Letter No.B3/6180/2017 Dated: 21.7.2017

Sub : CMDA – Area Plans Unit – ‘B’ Channel (North) – Planning Permission Application for the proposed construction of Stilt + 4 Floors Residential Building with 8 Dwelling Units availing Premium FSI at Old Door No.938 & 939, New Door No.156 & 158, Periyar EVR Salai (Poonamallee High Road) Purasawalkam, Chennai in T.S.No.20/3, 20/35 & 20/36 and 20/37, Block No.2 of Purasawalkam Village – Remittance of DC and other charges – Requested – Reg.

TERRACE FLOOR PLAN

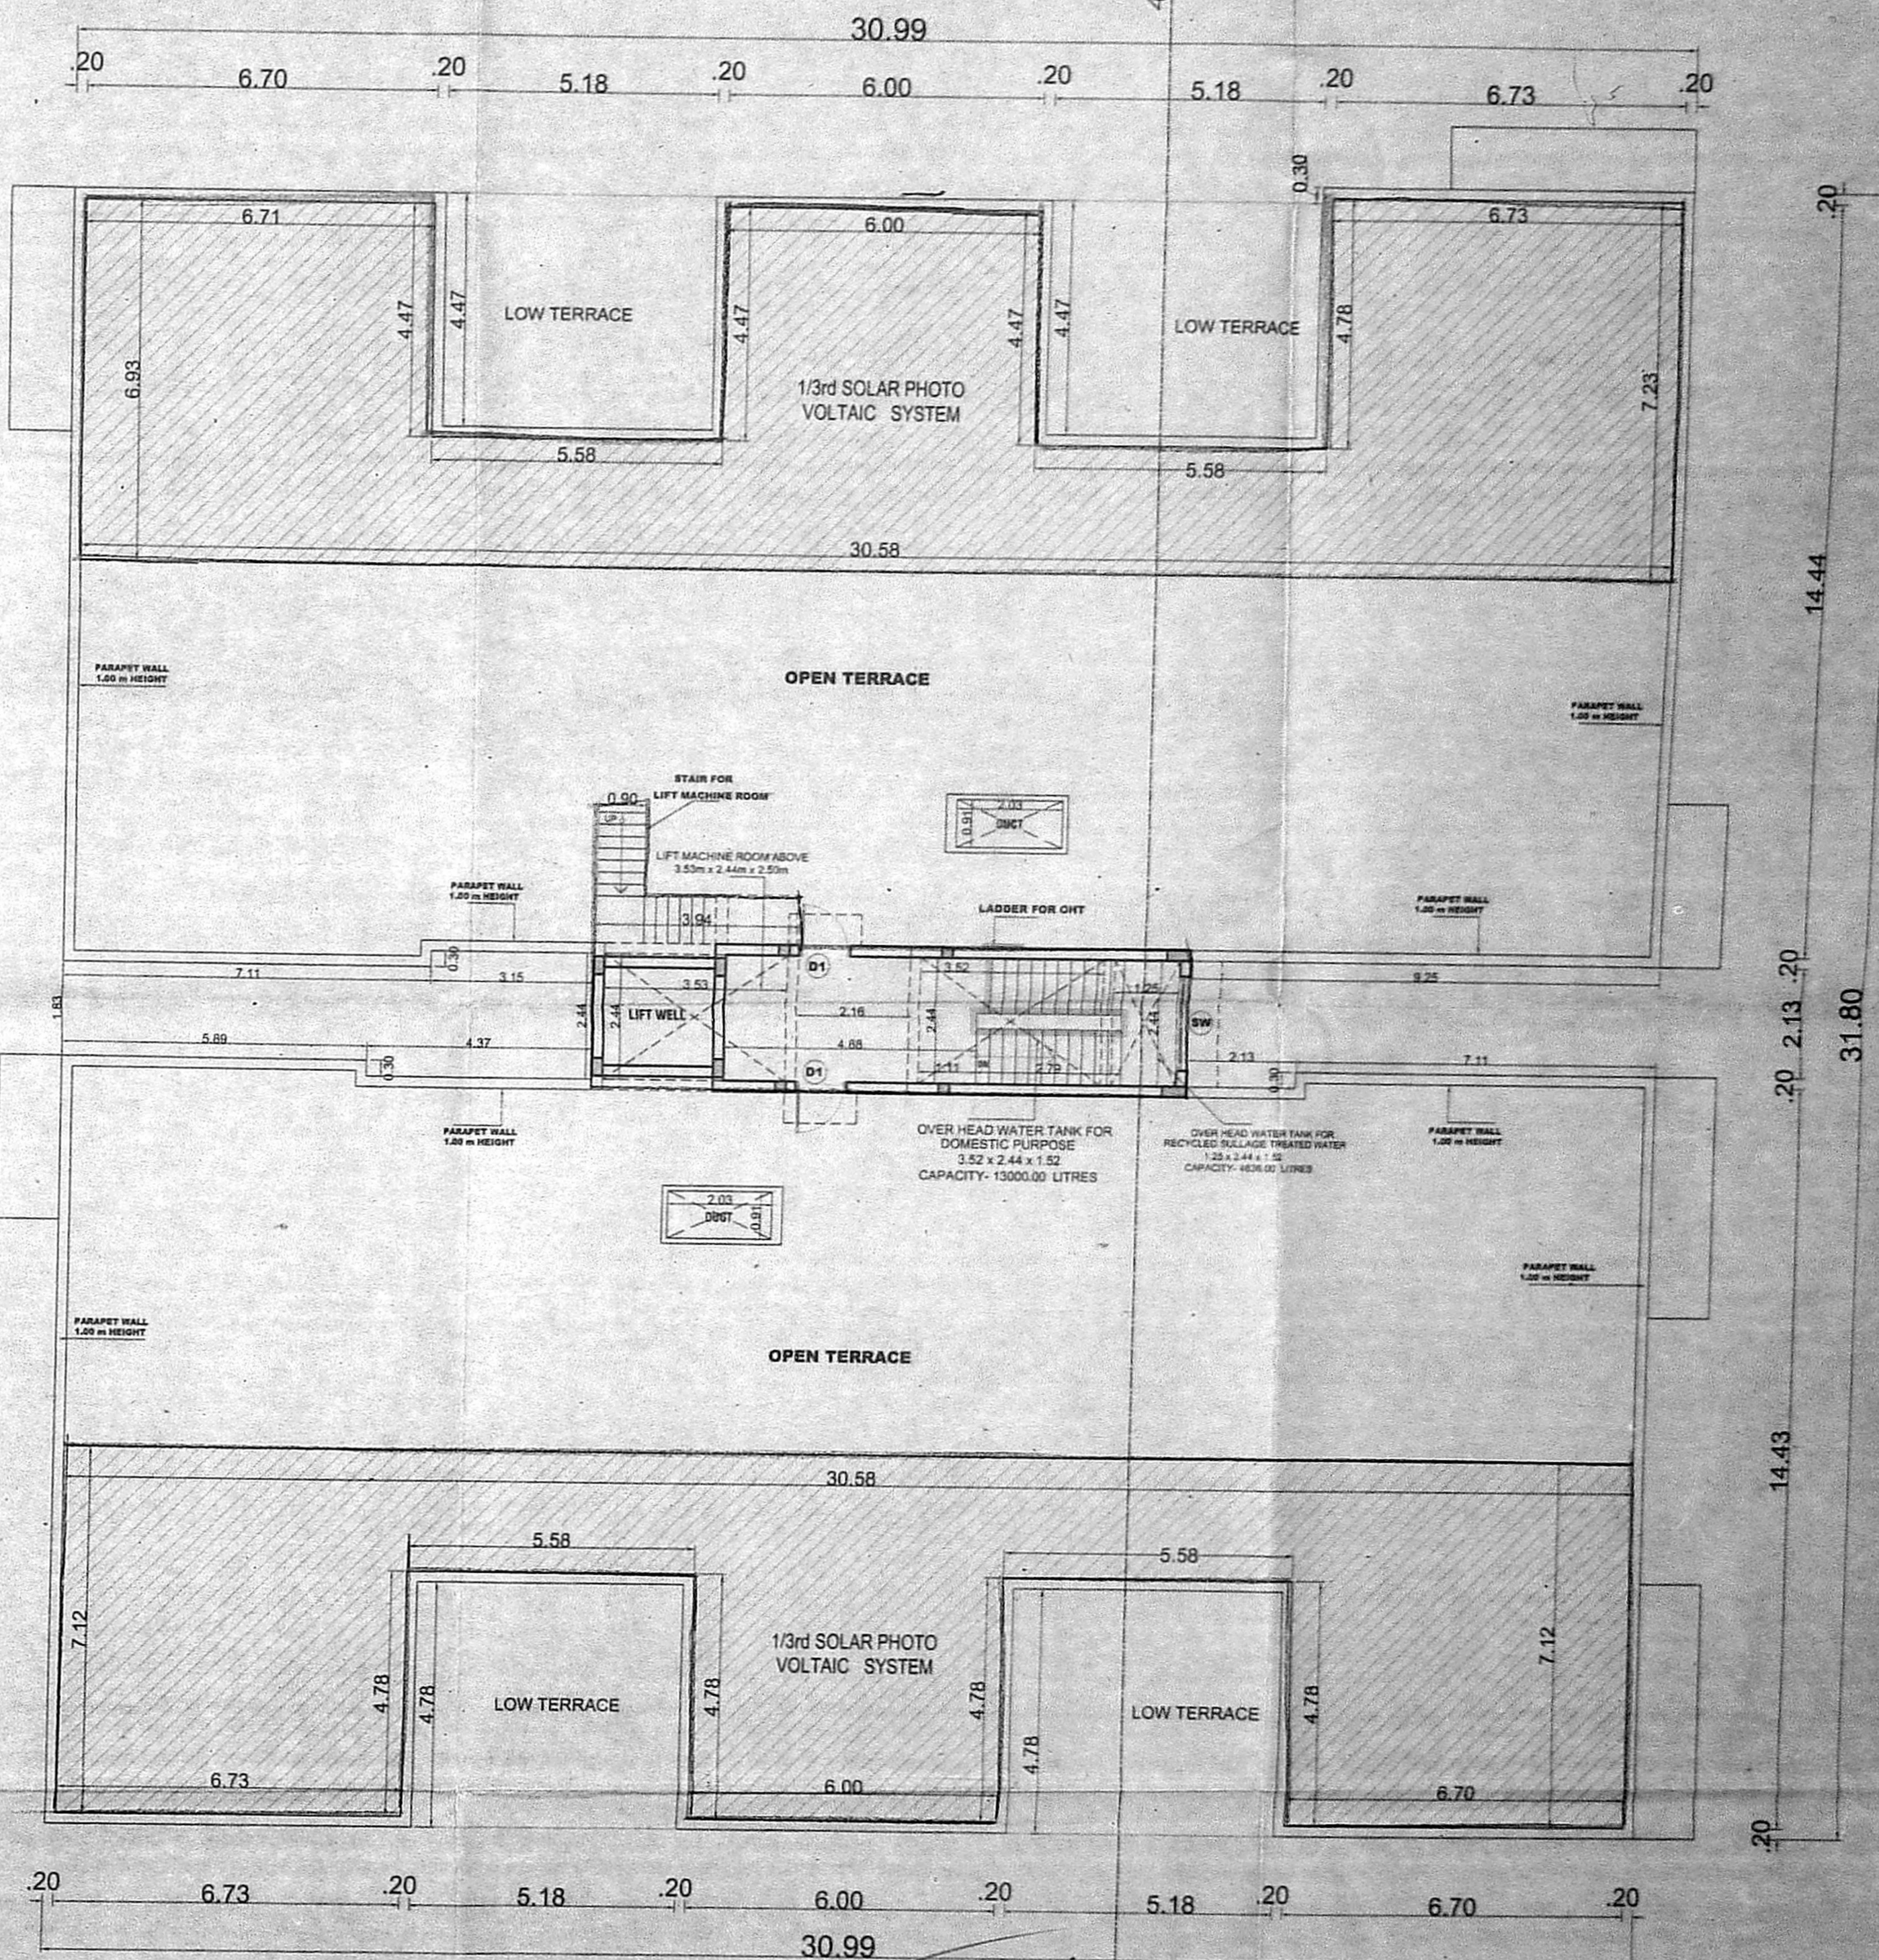
- 6) This demand notice (DC advice) pertaining to the proposed construction falls within the jurisdiction of **Greater Chennai Corporation**.
- 7) You are requested to furnish 5 copies of revised plan rectifying the following corrections:
1. Percolates not permissible in the open terrace portion.
  2. The site plan is to be drawn showing dimensions both as per Patta and as on site condition and distinguishing the difference by hatching and indicating the setbacks from least boundary line.
  3. Setbacks to be shown as per APPAS drawing.
  4. T.S.Number to be mentioned correctly in the title of the plan (T.S.No.20/3 instead of T.S.No.20/31).
  5. Rectification Deed document No.8256 of 1975, Court order in O.P.No.529 of 2014 and GPA document No.3724 of 2016 to be furnished.
  6. Area statement needs correction.
  7. Premium FSI Undertaking to be furnished.
